Please ask for: Mrs D Johnson
Email: daun.johnson@arun.gov.uk
Telephone: 01903 737762
Our Ref: BE/149/20/PL
Your Ref:
Date: 5th January 2021

Application for Planning Permission

Development: Replacement of blockwork boundary wall with fence & new vehicular access. This site is in CIL Zone 4 (Zero Rated) as other development.
Location: 339 Chichester Road Bersted PO21 5AN

SITE PLAN

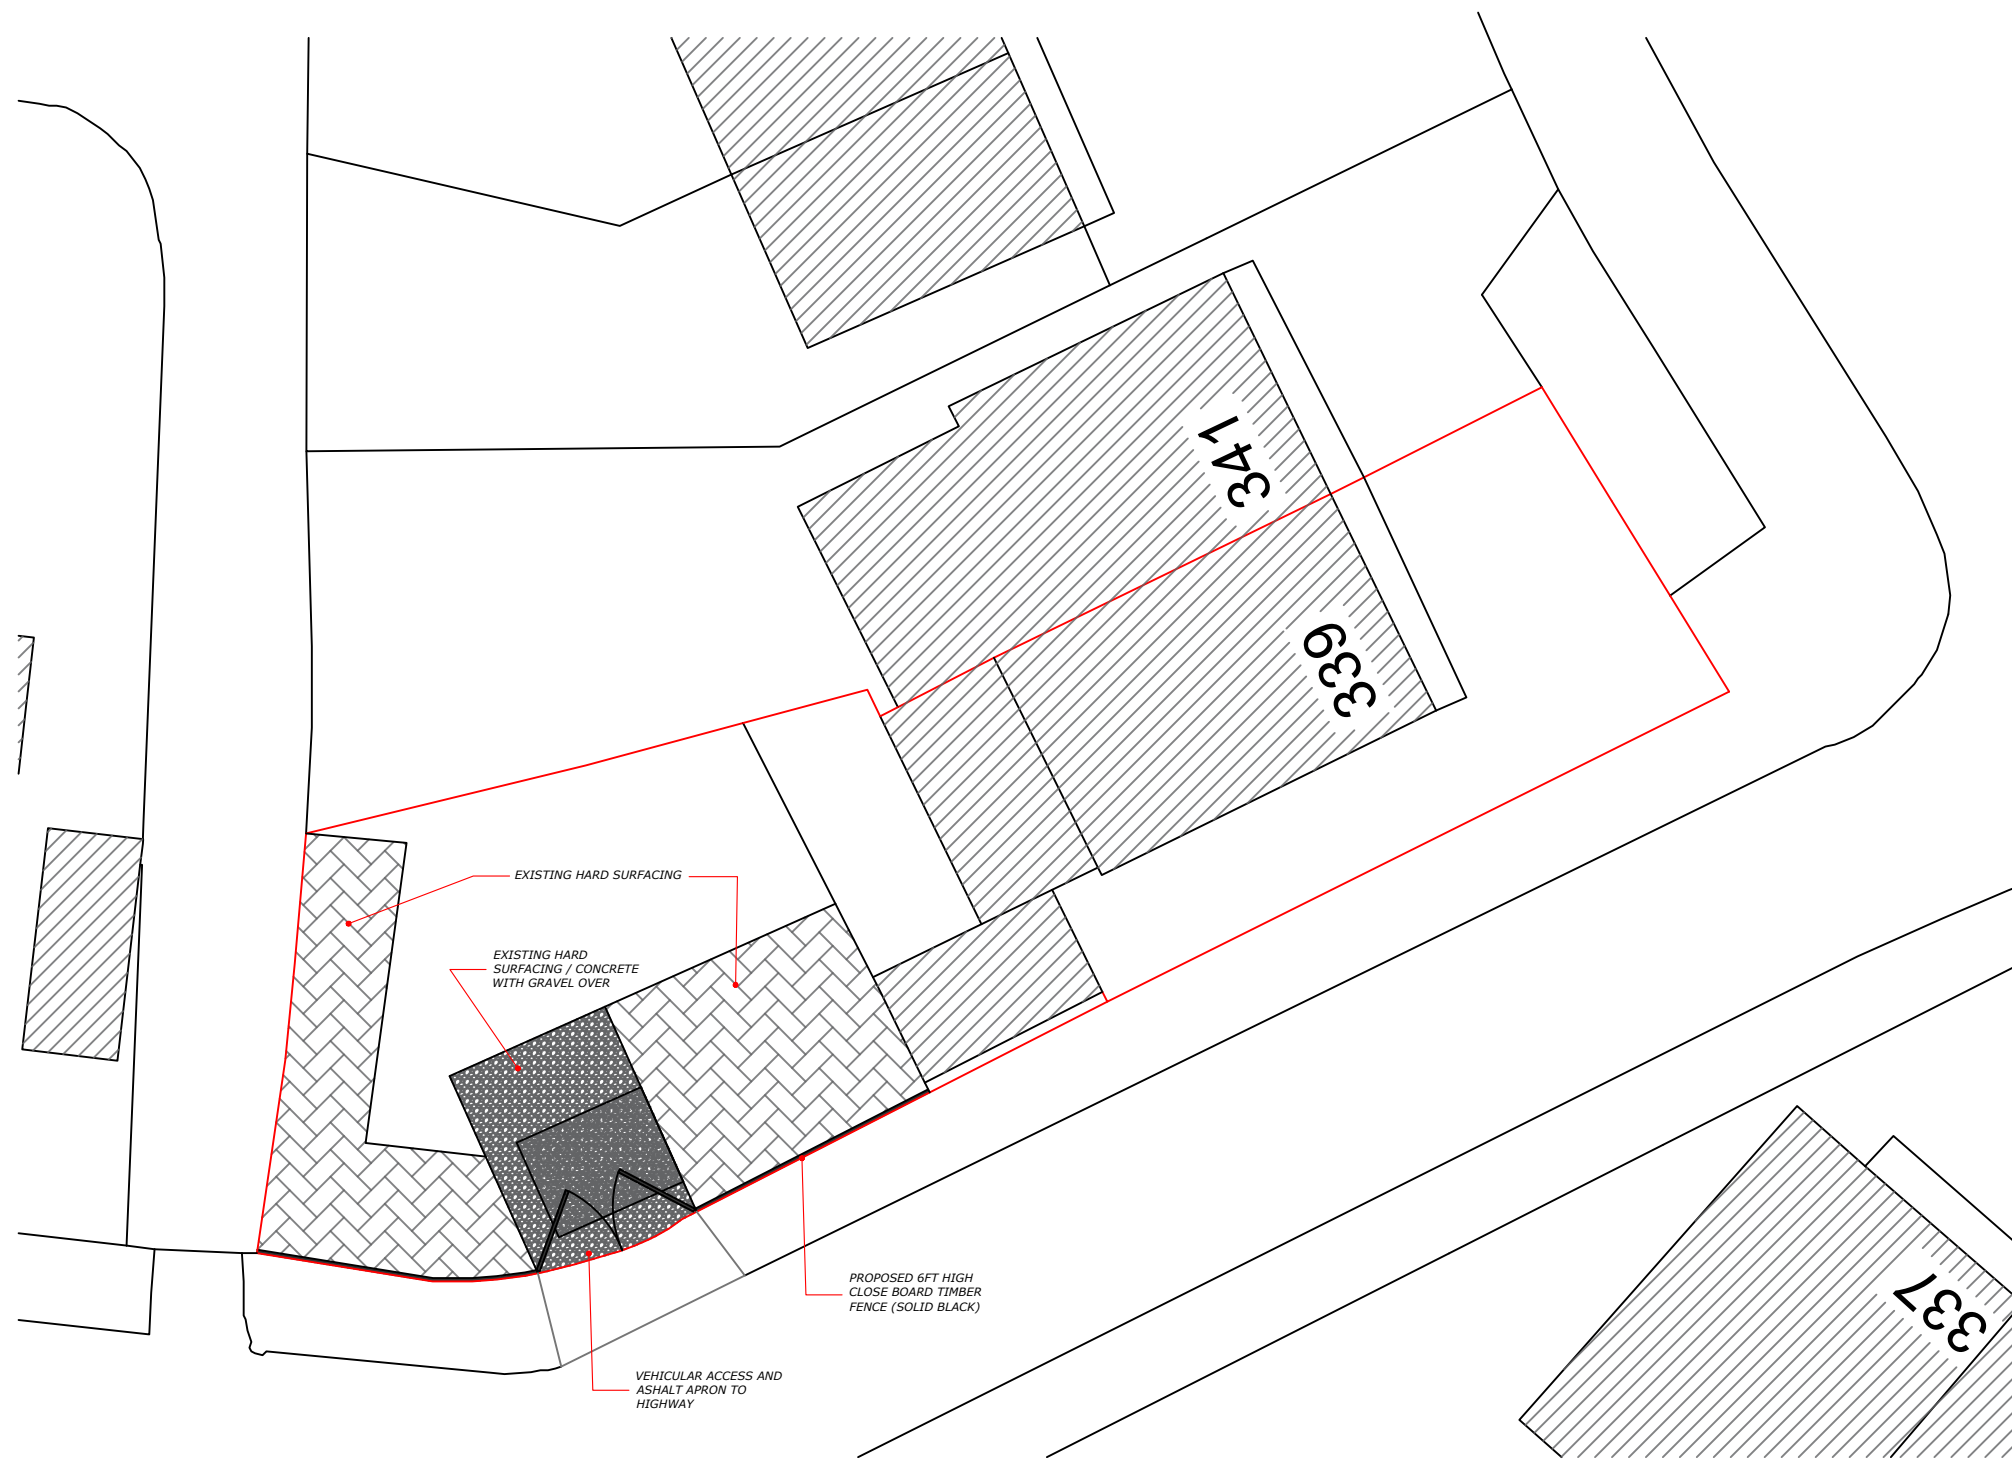
Block Plan

Please clearly highlight the position of the proposed fence.
CIL Additional Information Form

Please provide a photo or plan of the proposed fence.

West Sussex County Council require that a visibility splay is provided. A splay is formed for a 30 mph speed limit road by measuring from a point 2.4m back from the kerb edge in the centre of the proposed access. A line should then be drawn from either side of this point for 43 m in each direction to the nearside edge of the carriage way. The splays must intersect and only within the control of the applicant, or within the publicly maintained highway.

The distance will increase with the speed limit of the road. If the road is 40 mph speed limit then the distance should be 120 m either side. For speeds above this please contact West Sussex County Council Highways for advice on what would be acceptable.
